EPL 20434/DOC18/920867-2

**RE: SSD 09\_0103 – Boco Rock Wind Project (EPL 20434) – MOD 1 – Stage 2 Development**

## **Attachment 1 - SSD 09 0103 – Boco Rock Wind Project**

## Assessment Curves: Stage Two Mod = General Electric 5.3 MW-158

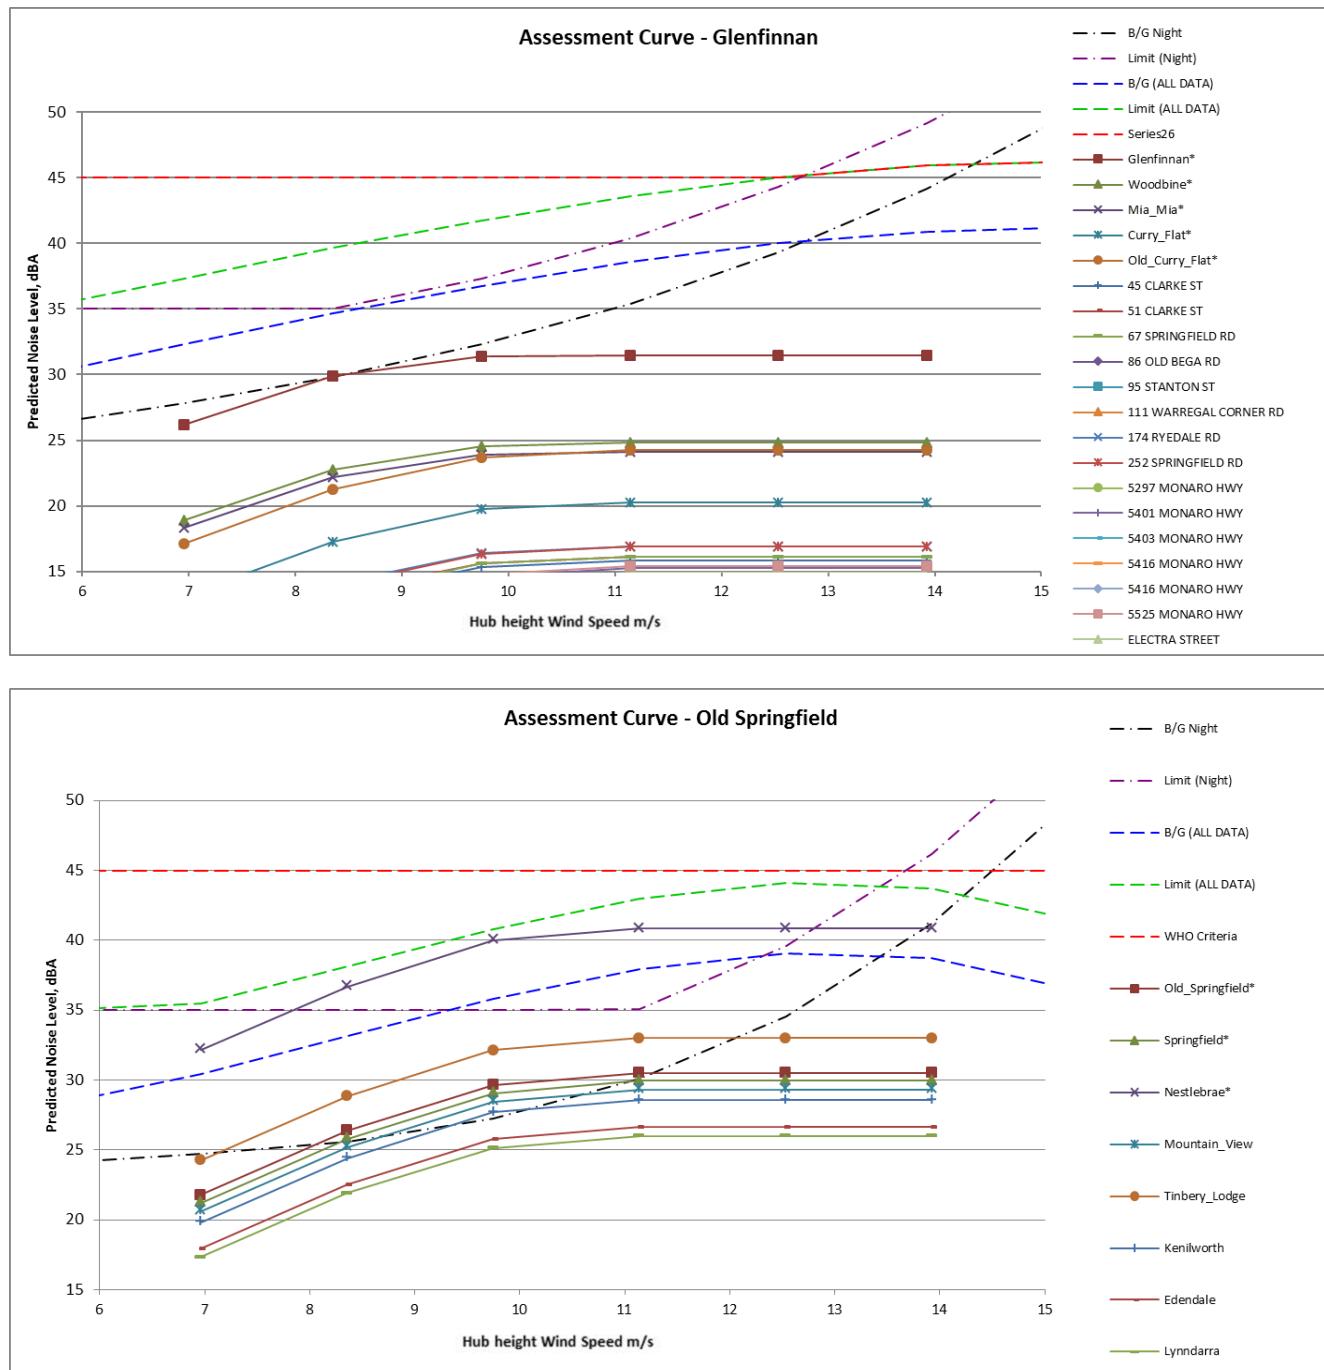
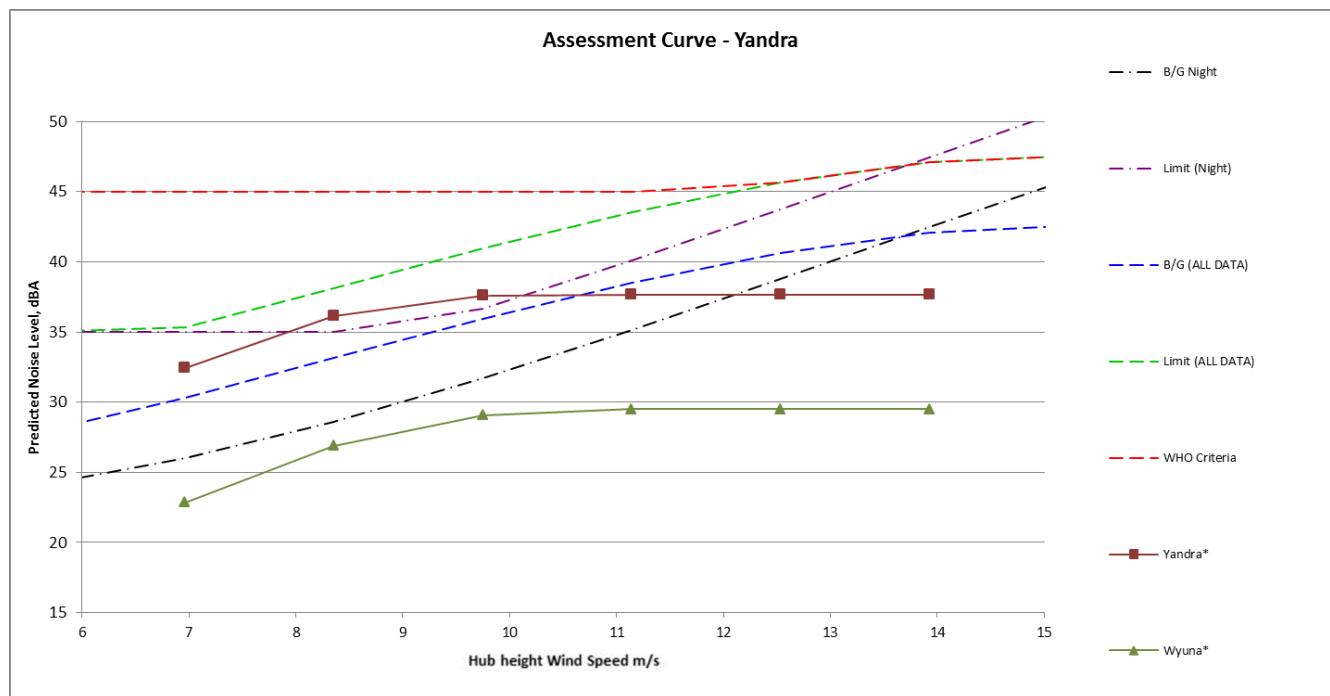
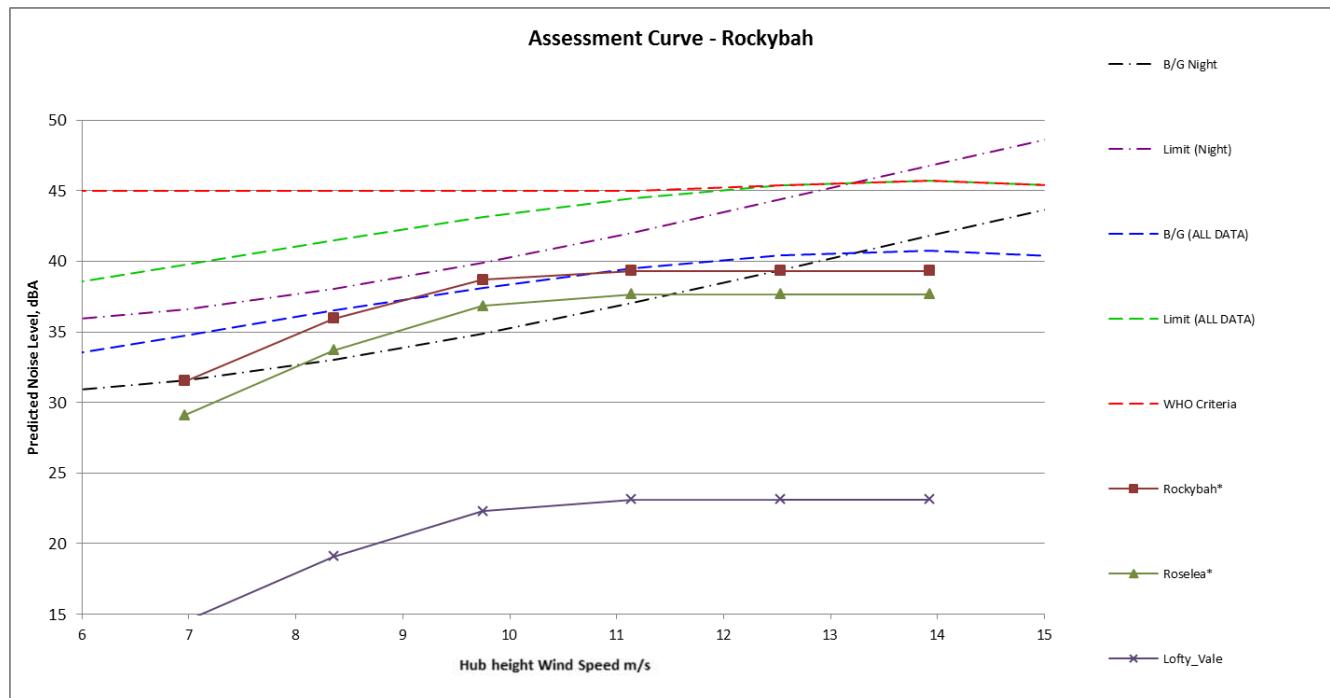
It is also not clear whether the background noise curves in Section 1.1.3, on which the Project criteria are based, have not been derived for winds at WTG hub height. This should be clarified in the RNA.

The EPA also note that Table 9 quotes WTG sound power levels for wind speeds at 10m above ground level. The proponent should explain how these sound power levels are appropriate when predicting noise for wind speeds at hub height.

## Noise Contours

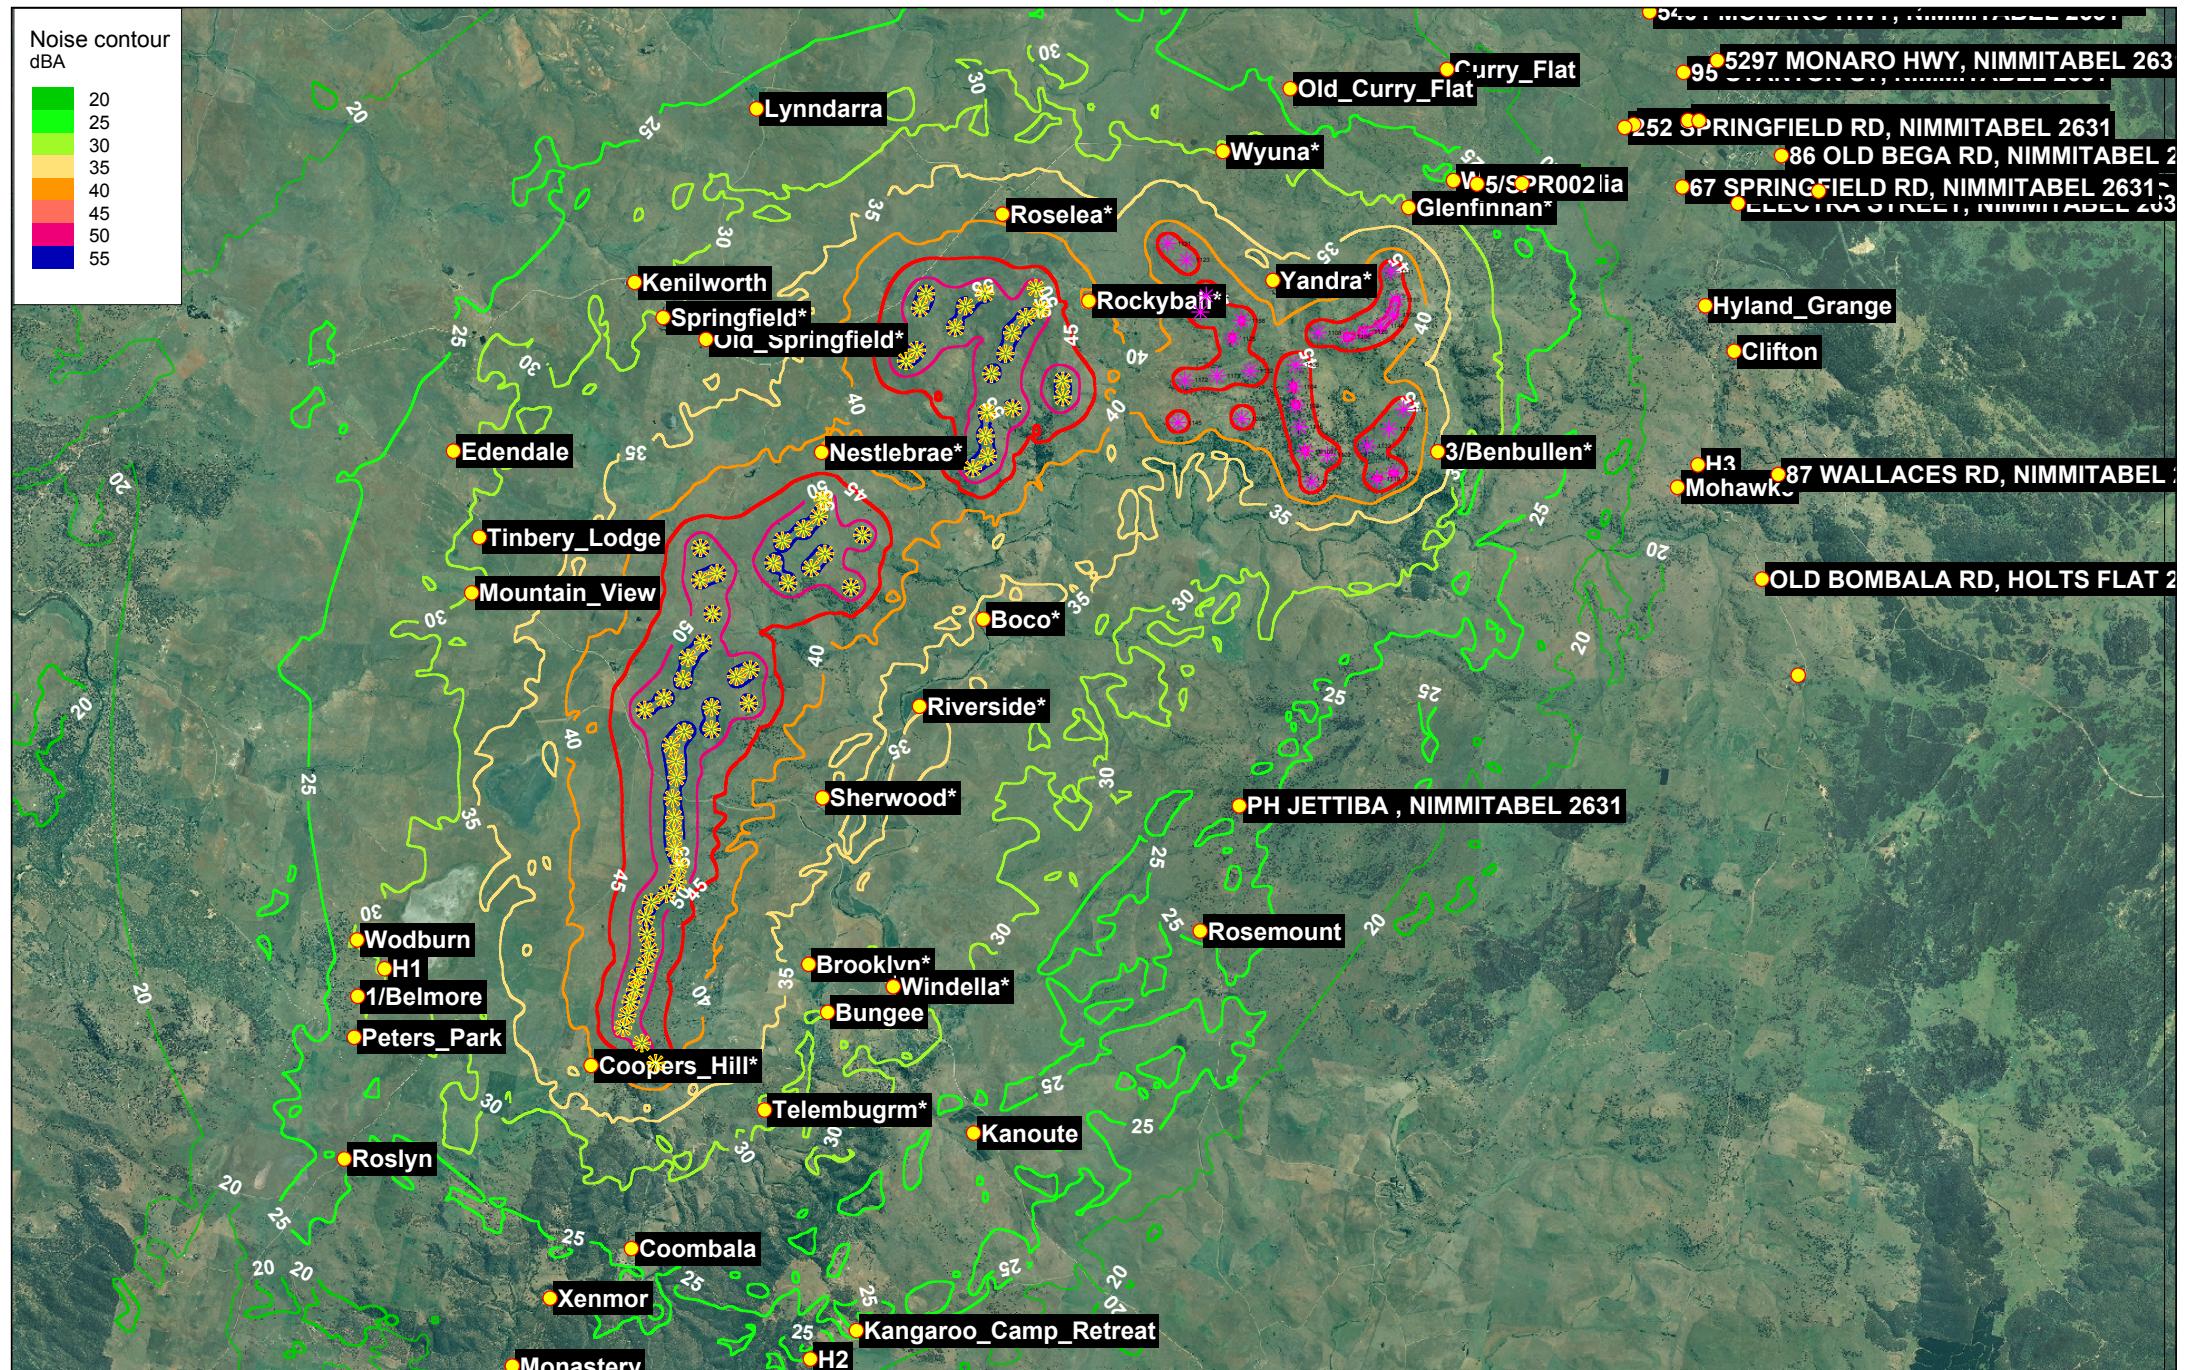
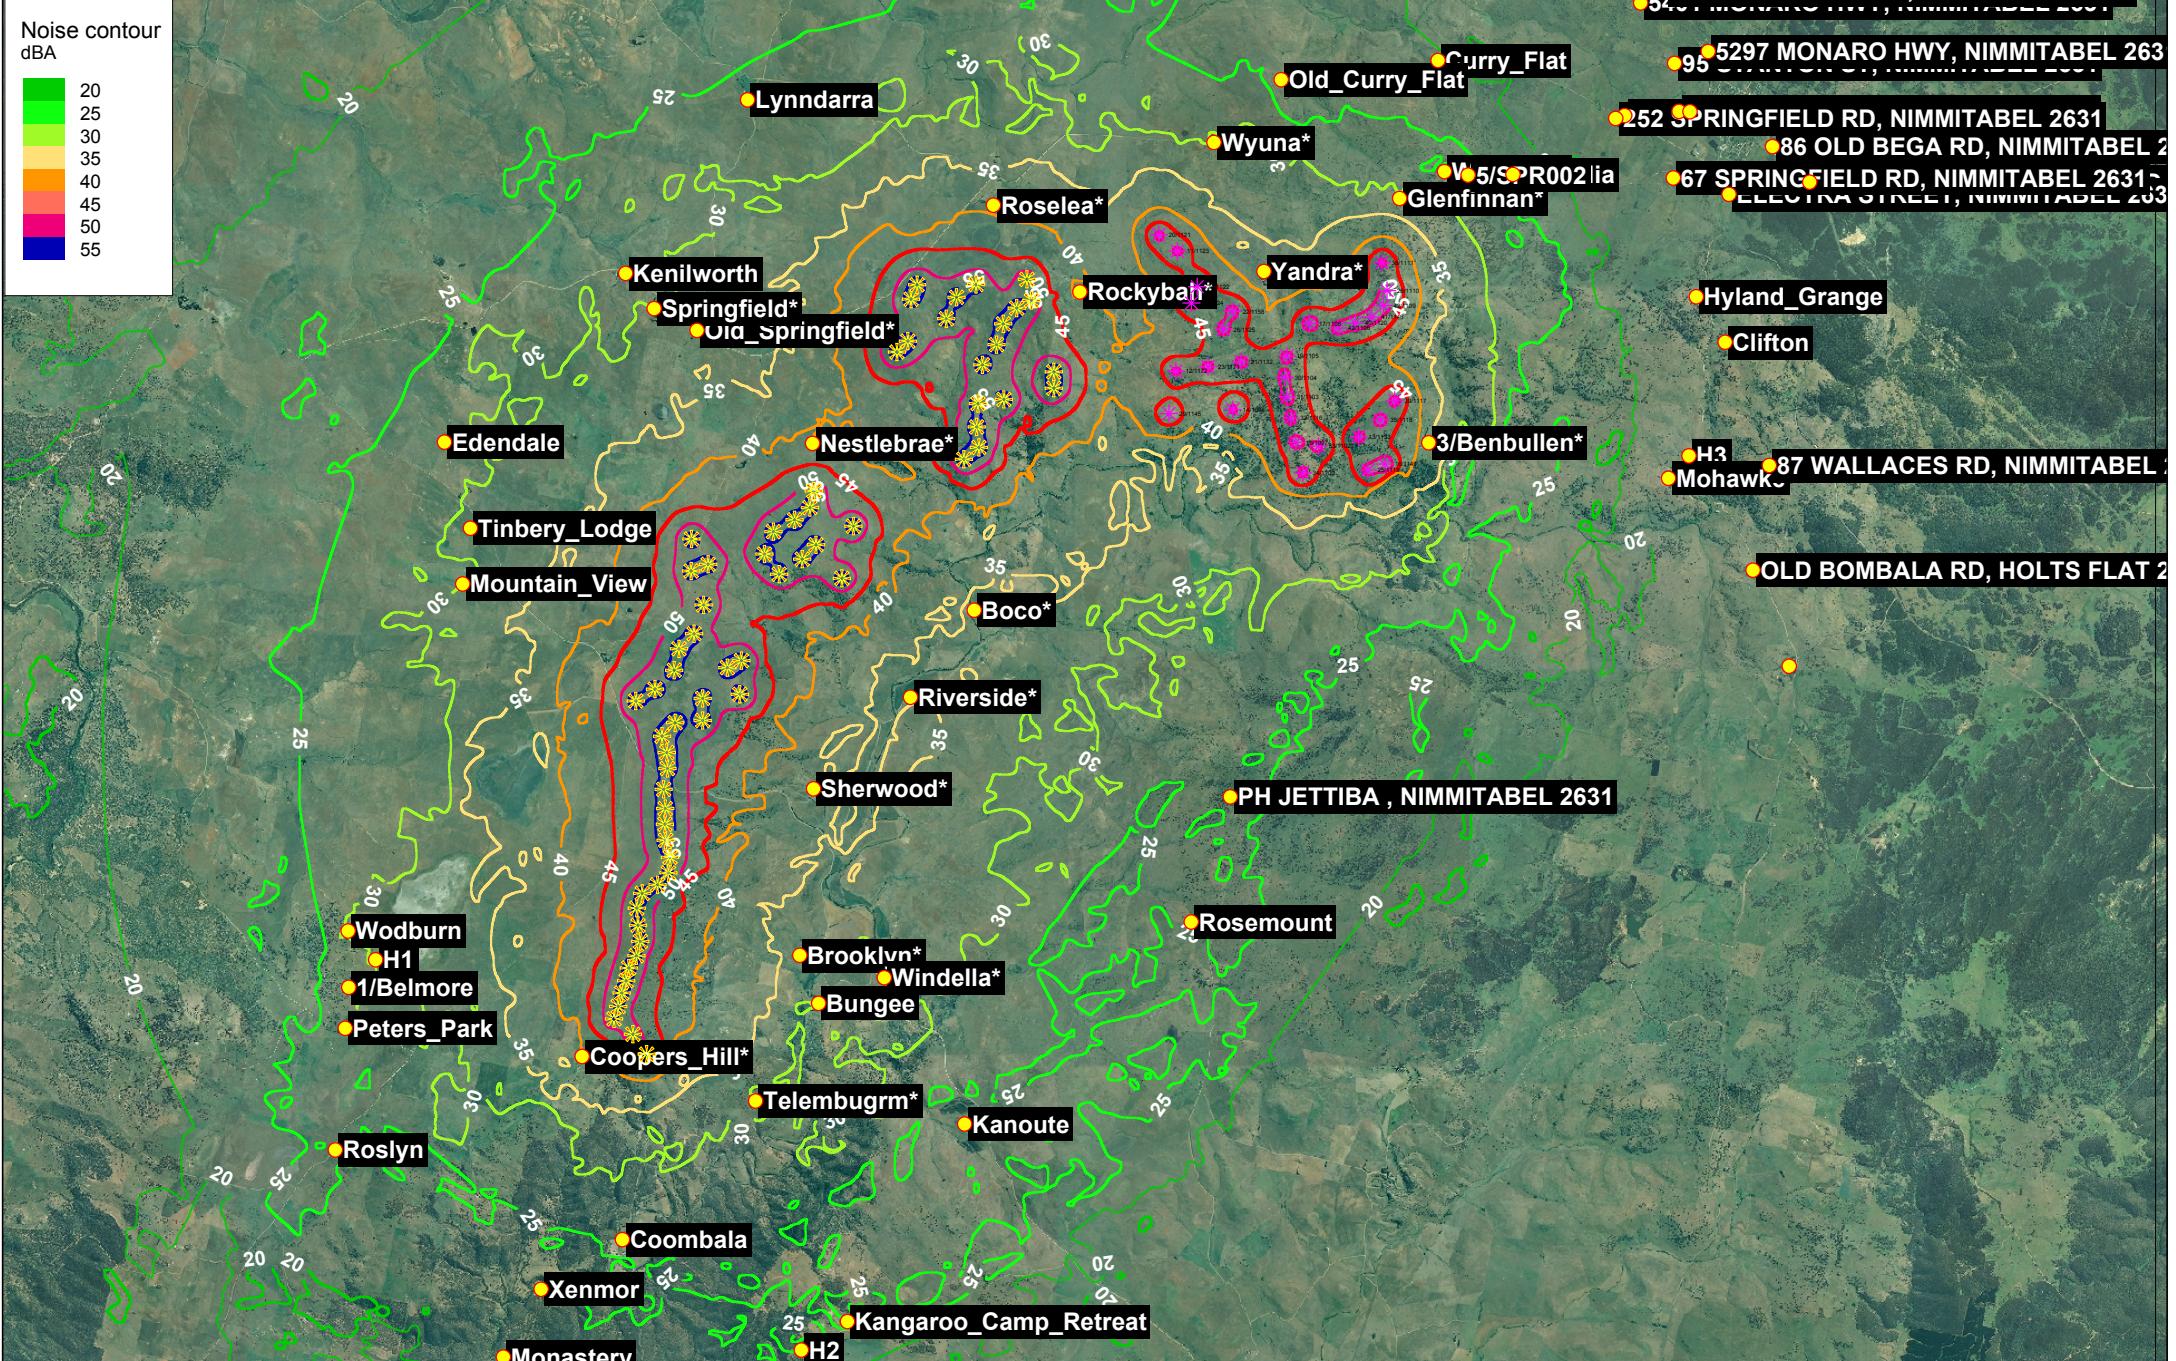
The noise contours in Appendix C are labelled as being for wind speeds of 8 m/s at hub height, although it is unclear how these contours relate to the numerical noise predictions on Section 5.2. The numerical predicted noise levels for wind speeds at hub height for each non-involved receiver and the corresponding noise contour maps should be reviewed and checked for consistency.
